STATE OF NORTH CAROLINA
DEPARTMENT OF TRANSPORTATION

Addendum No. 1

RE: Contract # C204467

I-40 FROM MILE MARKER 50 TO MILE MARKER 55.

STATE	PROJECT NO.	SHEET NO.	TOTAL SHEETS
N.C.	1-6063	9	
F.A. PROJECT NO.

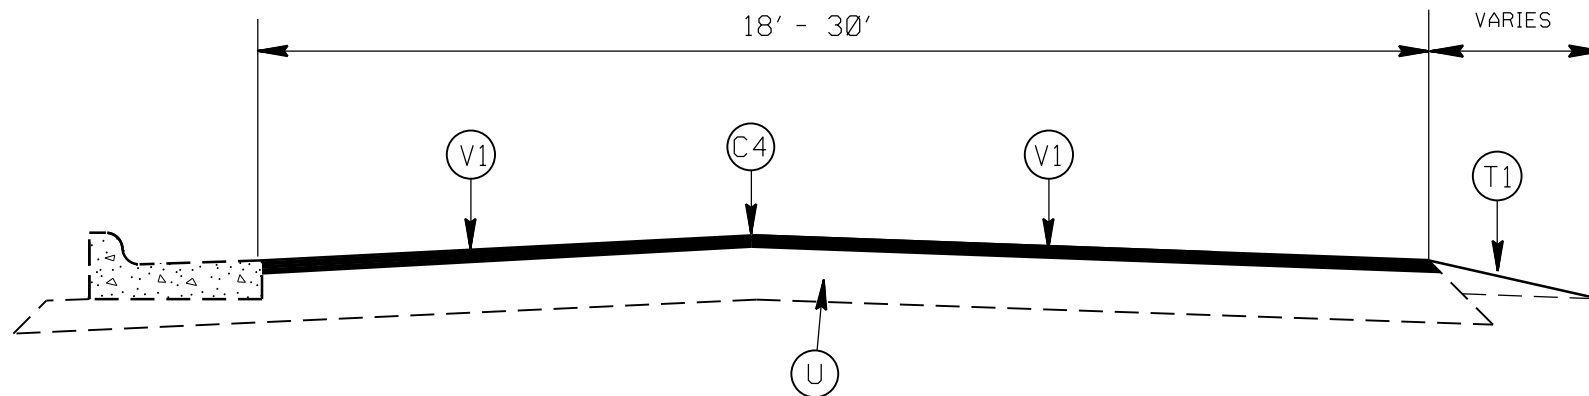
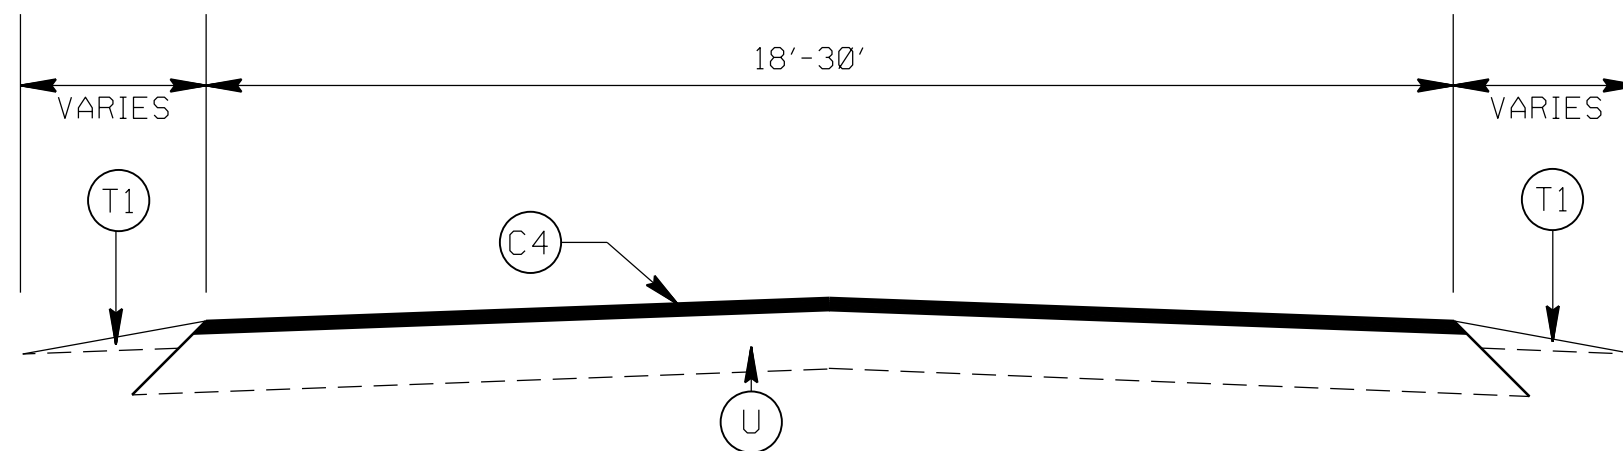
Sheet No.	Revision
5	Revised to correct line weights
8	Revised to include Z1 (Fine Milling)
9	Revised to include notes for On Ramp SB Hendersonville Rd.
New Sheet 13A	Sheet added for Concrete Barrier Single Slope Detail
21	Summary of Quantities revised for pay item corrections
